Arun District Council
Arun Civic Centre
Maltravers Road
Littlehampton
West Sussex BN17 5LF
Planning & Building Control General
Enquiries

18th February 2011

Replacement dwelling
44 Broadmark Lane Rustington

DRW NO 3a SCALE 1/50
 PROPOSED ROOF PLAN

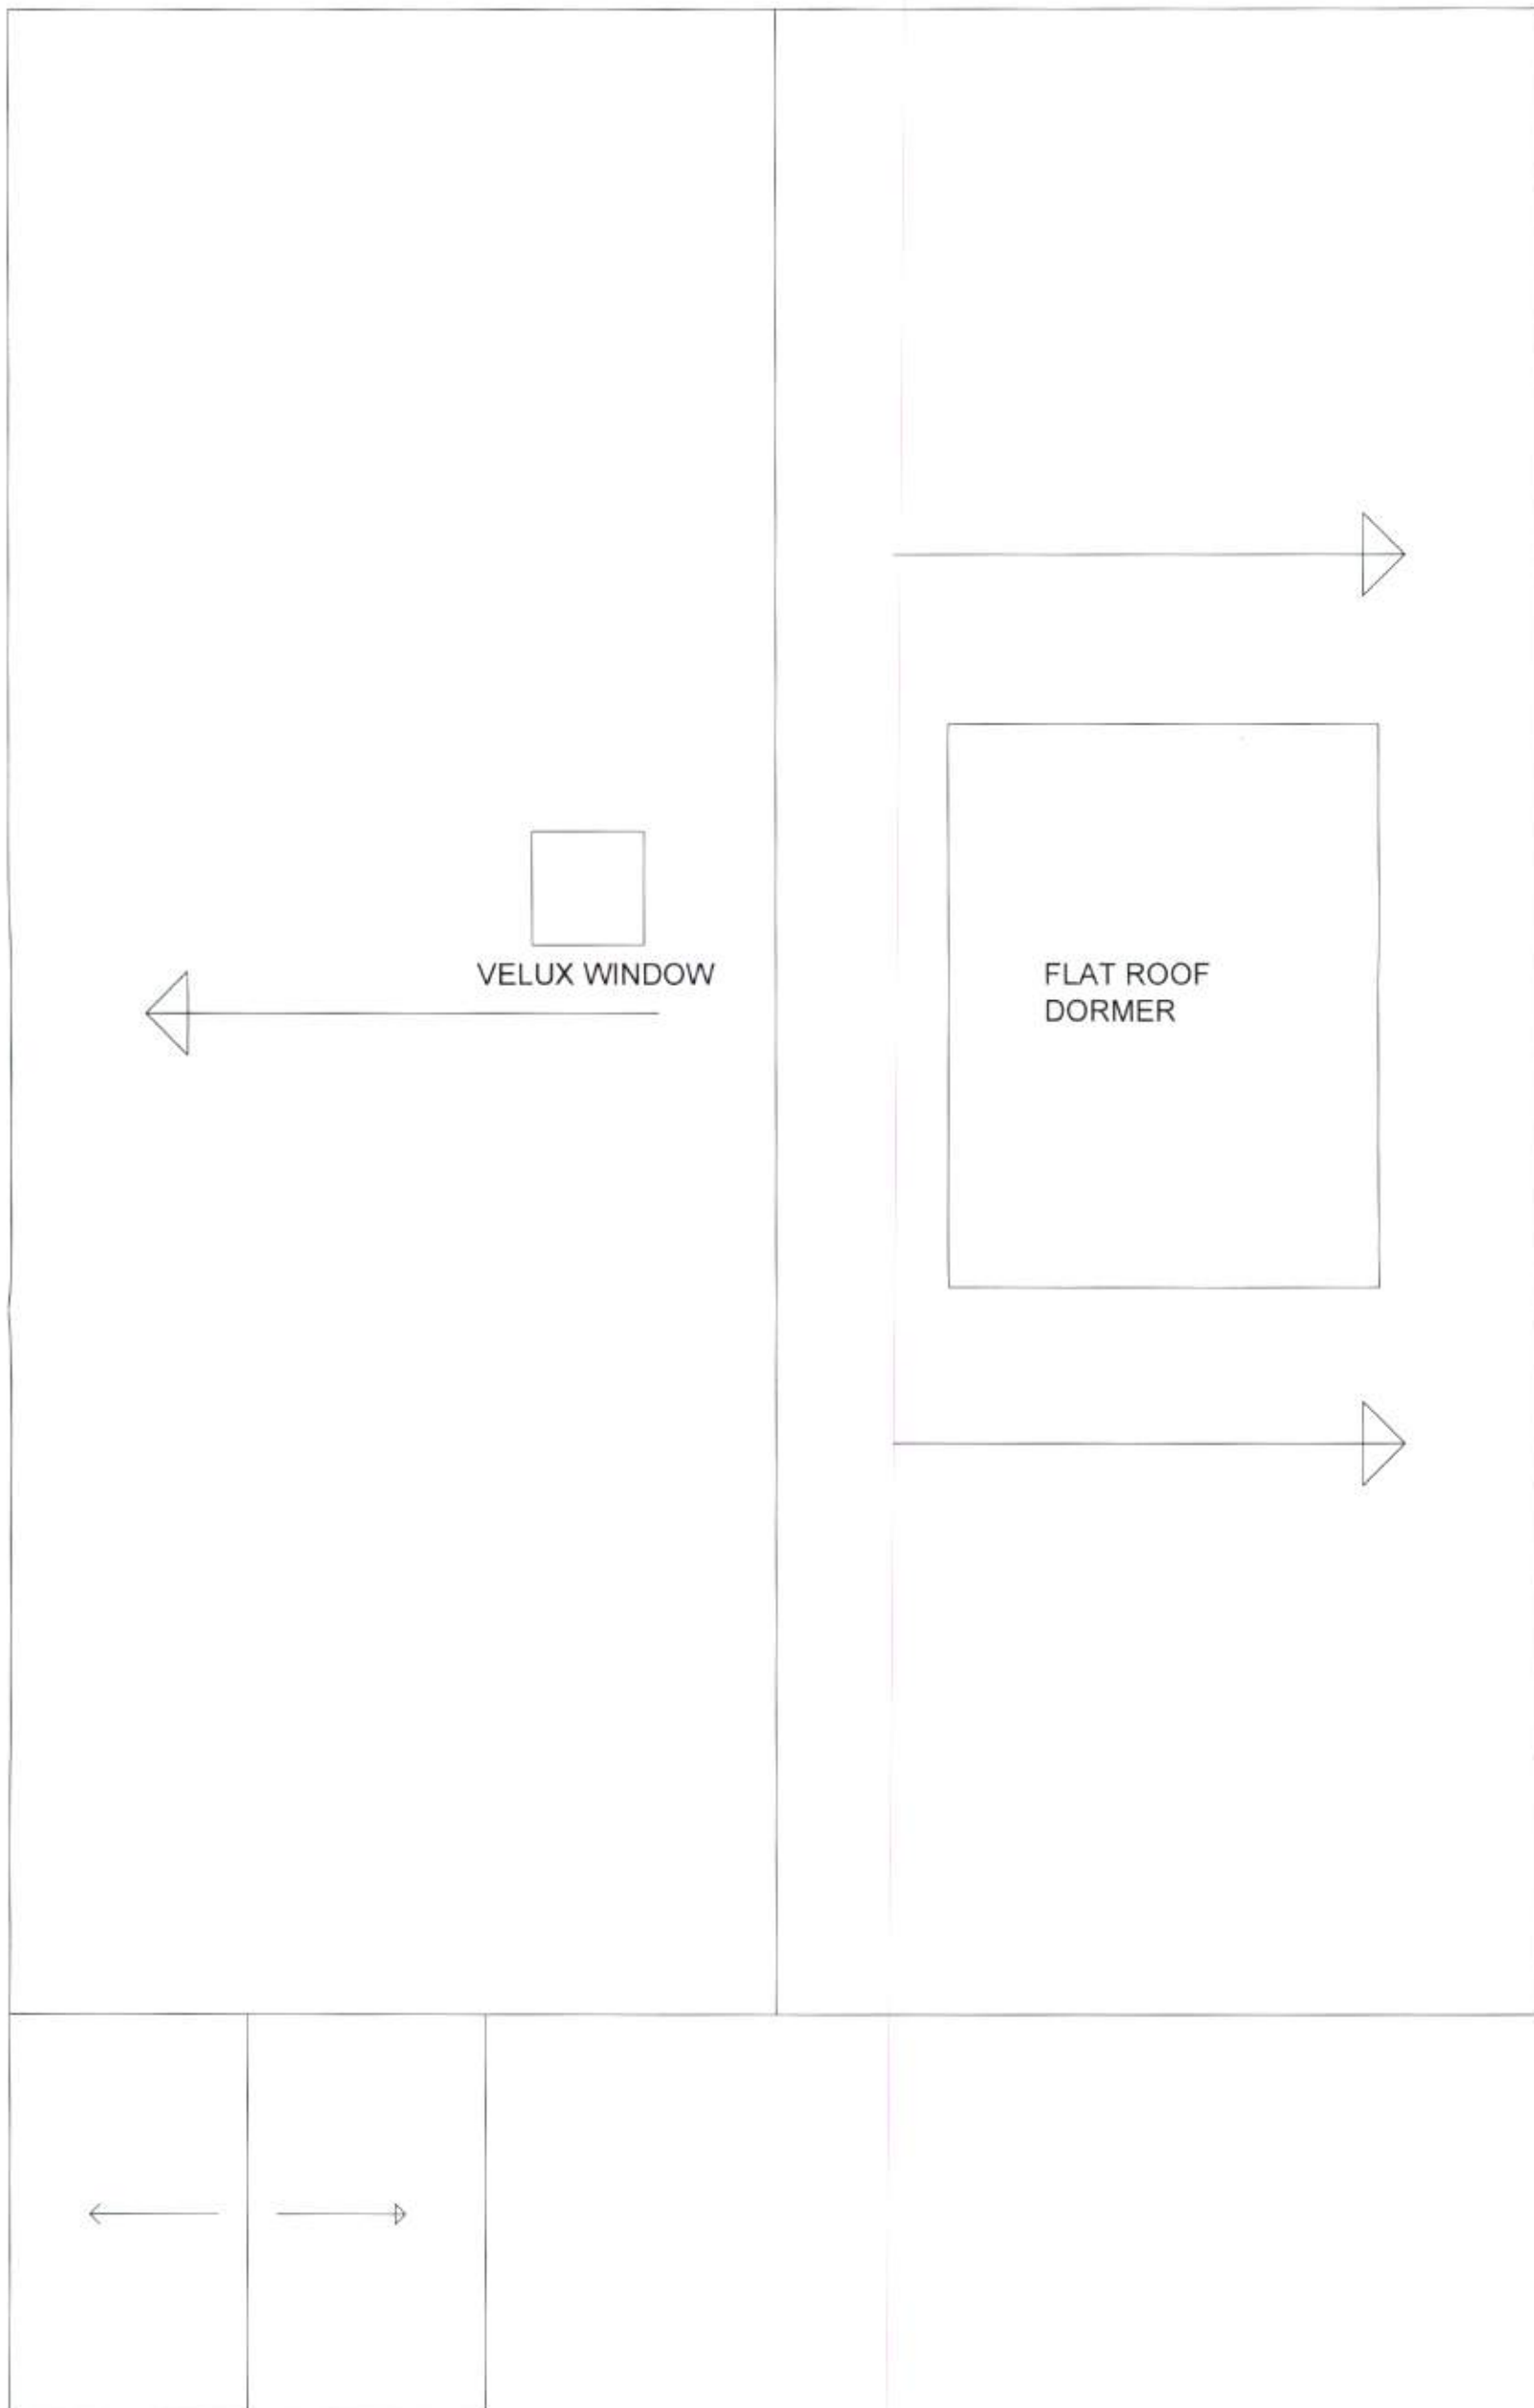
Please submit 1 electronic or 3 paper copies of a revised proposed roof plan to show the dormer section.
